City of Mercer Island
9611 SE 36th Street
Mercer Island, WA 98040-3732

October 17, 2019

Attn: Ms. Nichole Gaudette
Senior Planner
Regarding - CAO-19-019

HILLSIDE IMPROVEMENTS PLAN

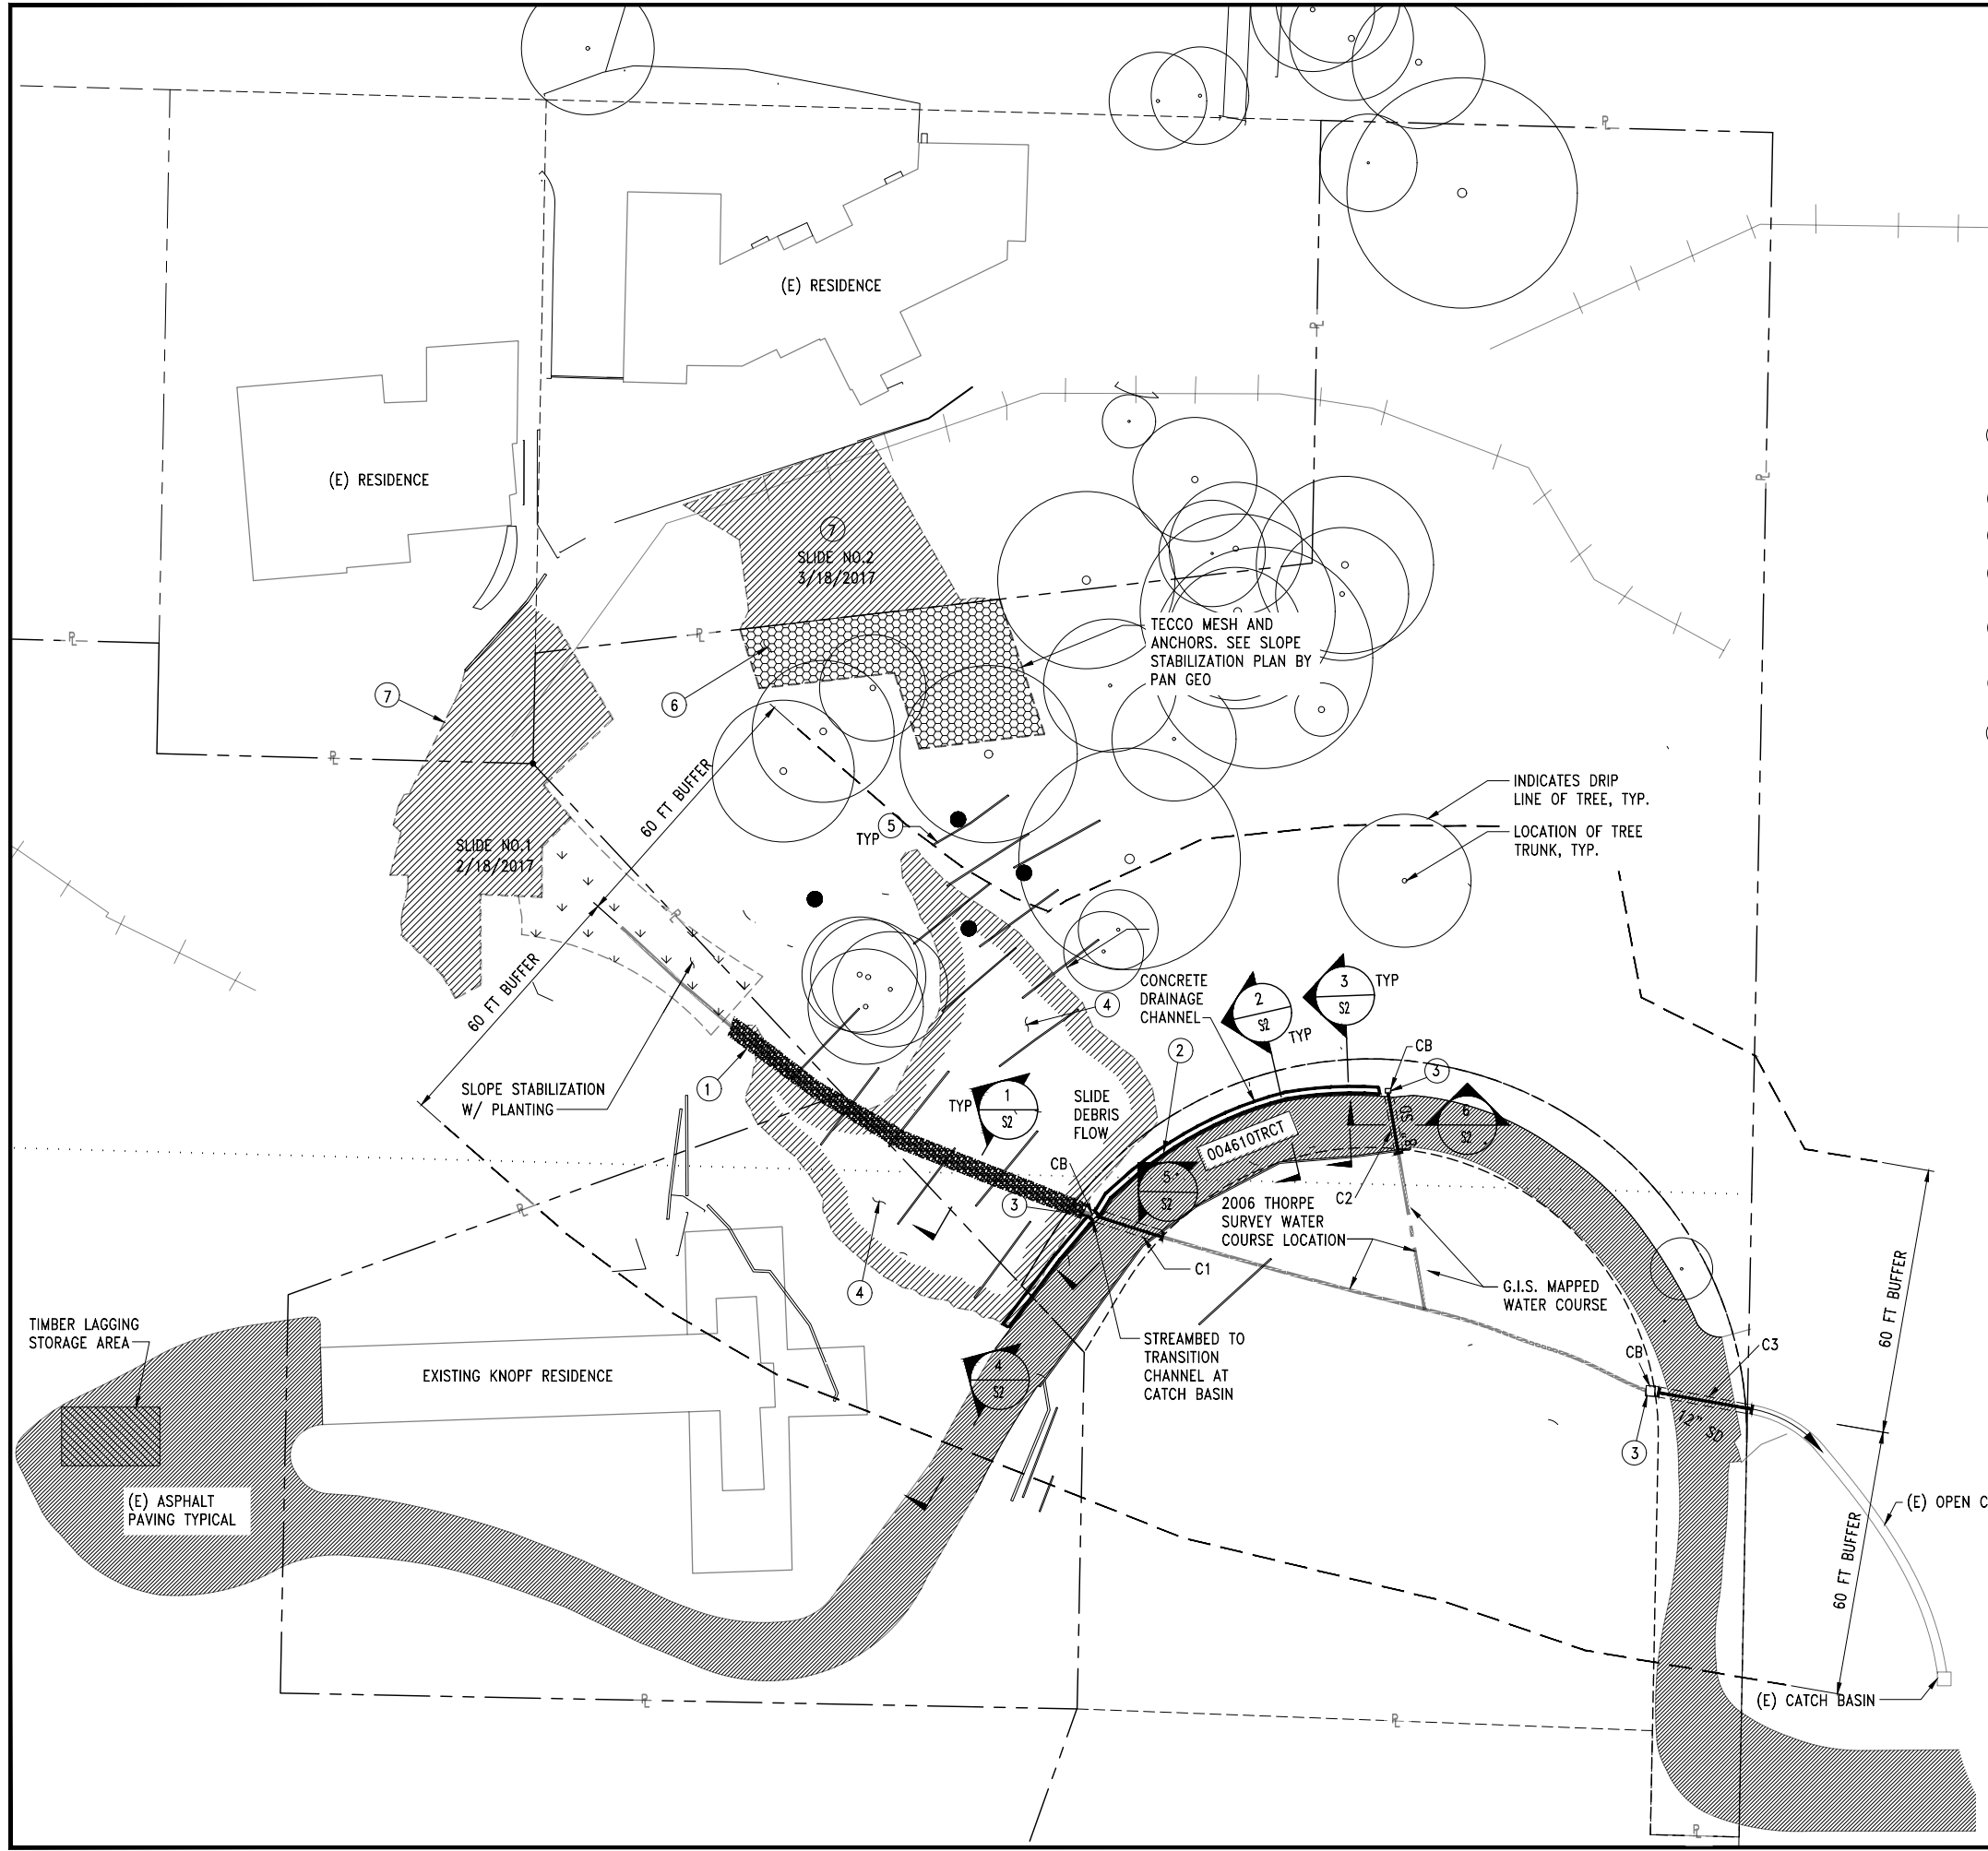
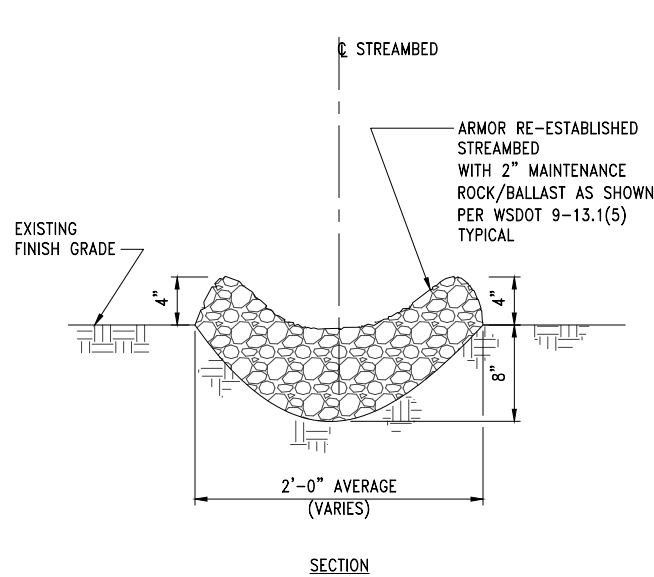
10. According to the HCE Permit Set plans, one of the proposed restoration activities includes removing the existing upper catch basin and plugging the adjoining culvert. This activity would route water flow collected from the hillside, along the uphill side of the driveway, into the lower catch basin. Currently, the upper catch basin and adjoining culvert provide water flow to an existing stream channel downslope of the driveway.

This proposed activity is not considered restoration of the stream or an allowed modification per MICC 19.07.130.B. Instead, this project element would serve to divert water away from the original location of the watercourse. In addition, the HCE Permit Set plans indicate that the section of existing stream channel located downslope of the driveway will be re-aligned, but the plans do not provide any details for how this will be completed. The details regarding re-alignment of the stream are necessary for assessing the proposal's consistency with MICC Chapter 19.07. Re-aligning an existing stream channel may not be allowed by code if other alternatives with lesser impact are feasible. The removal of the upper catch basin and plugging of the adjoining culvert in the HCE Permit Set plans should be reevaluated so current water flow is not completely re-routed from the existing downslope stream channel. The HCE Permit Set should be revised to include details regarding the re-alignment of the existing downslope stream channel.

11. According to MICC 19.07.180.C, the standard buffer for a Type Np stream is 60 feet. Based on the HCE Permit Set plans a 50-foot stream buffer is proposed. Please increase the buffer to 60-feet.

We are no longer removing any catch basing or blocking culverts. The stream will continue to flow in its historical location with no diversions.

The 60 foot buffer has been updated on the drawing set.

KNOPF RESIDENCE
9507 SE 43rd Street
MERCER ISLAND WA, 98040
HILLSIDE IMPROVEMENTS DETAILS

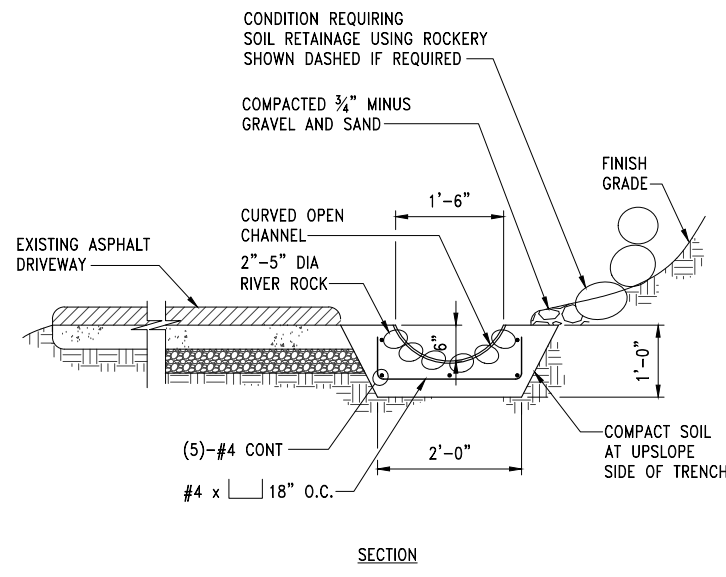
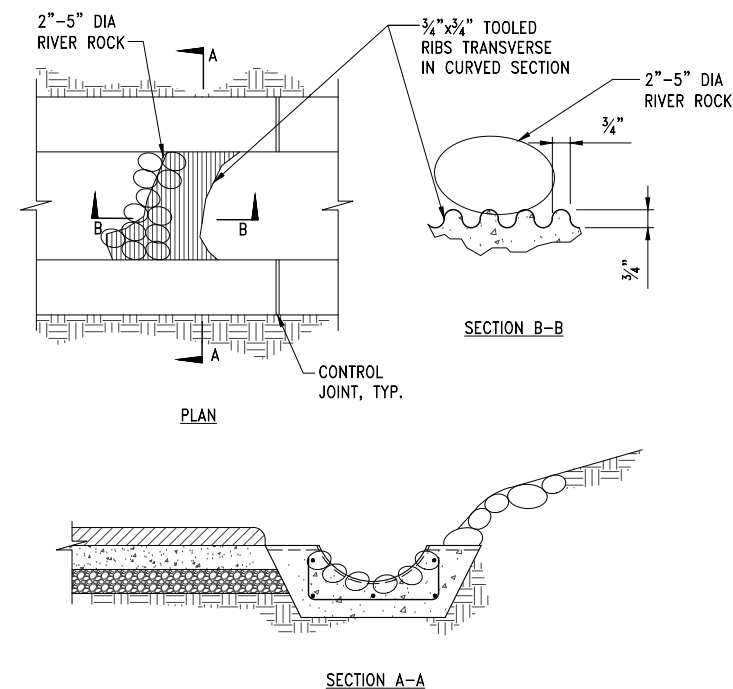
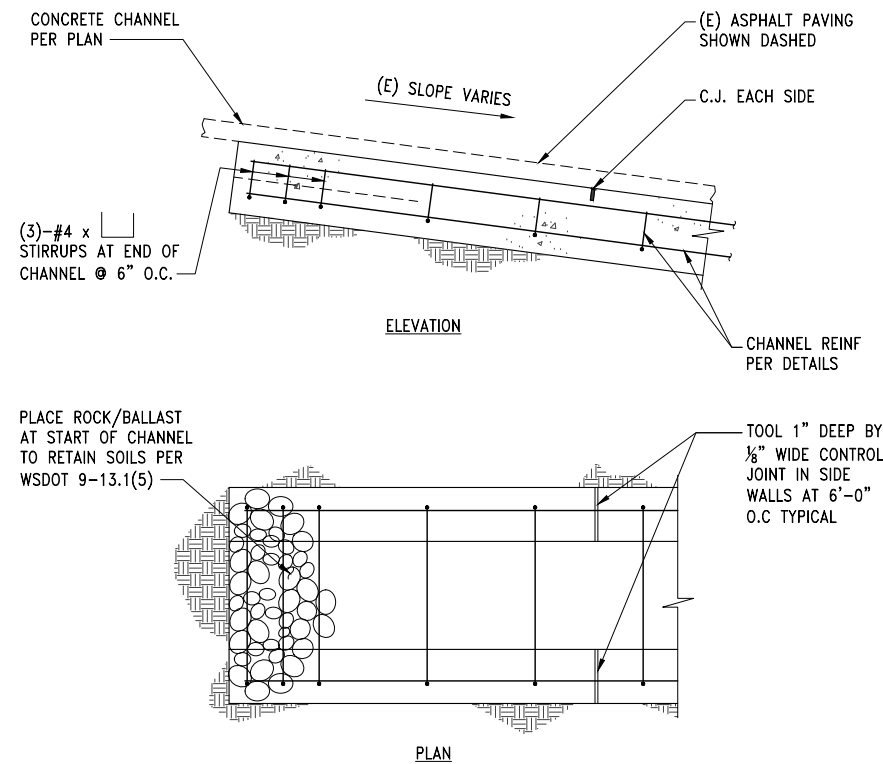
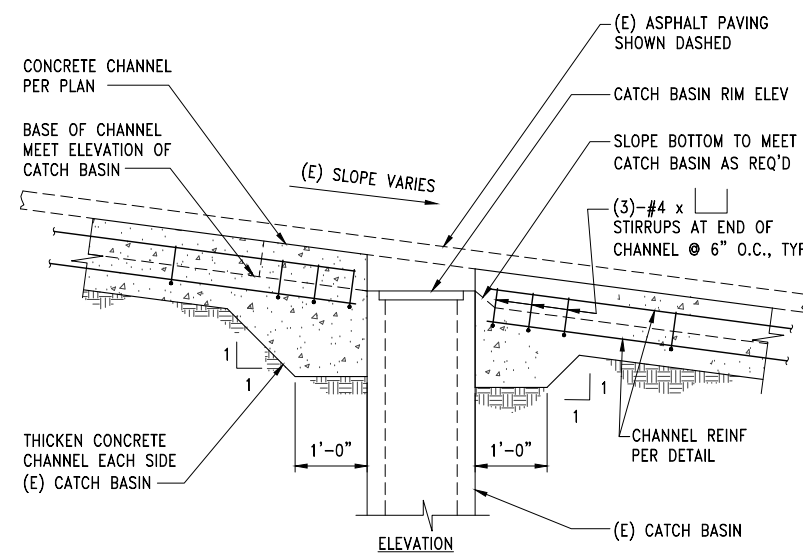
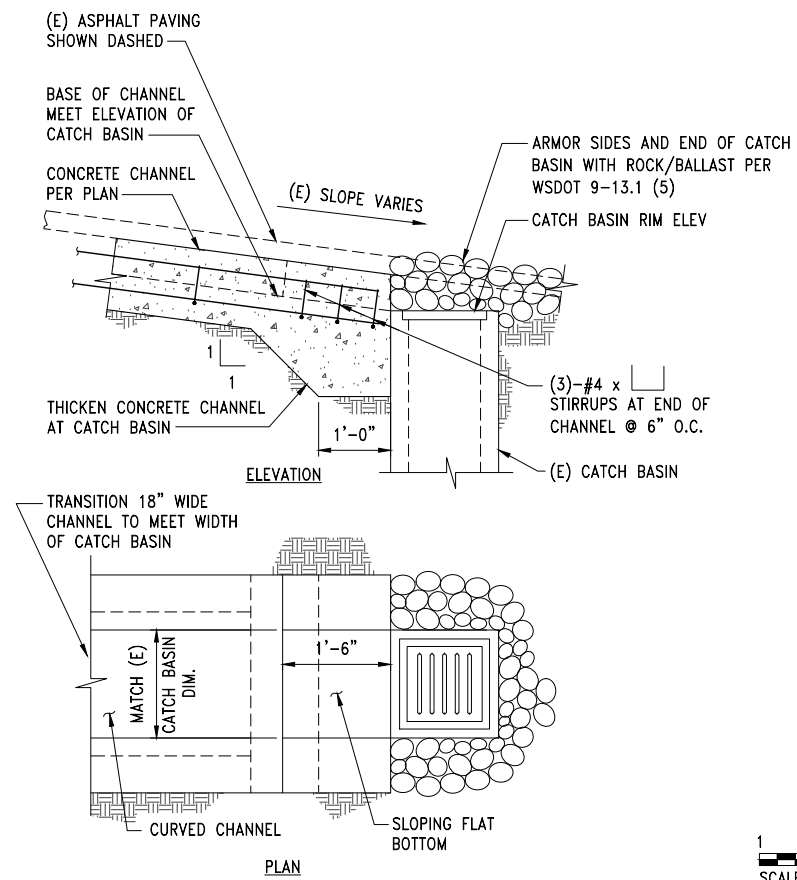
12. Based on review of the September 4, 2019 Landslide Restoration Recommendations Letter prepared by Pan Geo, Inc., the concrete-lined trench may be a viable alternative to the original proposed system as it would include fewer artificial components; however, there are two concerns associated with this alternative. First, we are concerned that a concrete lined trench could alter peak flows and potentially lead to downstream erosion and scour of the open channel. This issue should be addressed in any future proposals for the alternative. Second, barring further design details, we are concerned this alternative could include removing the upper catch basin and plugging the adjoining culvert, similar to the original proposed system. If this activity is included, we do not believe the alternative would be considered restoration of the stream and an allowed modification per MICC 19.07.130.B. Ensure that any future proposals for the concrete-lined trench consider the issues presented above.

The concrete drainage channel will be 'roughened' to slow down the flows during peak events. See detail 8 / S-1.
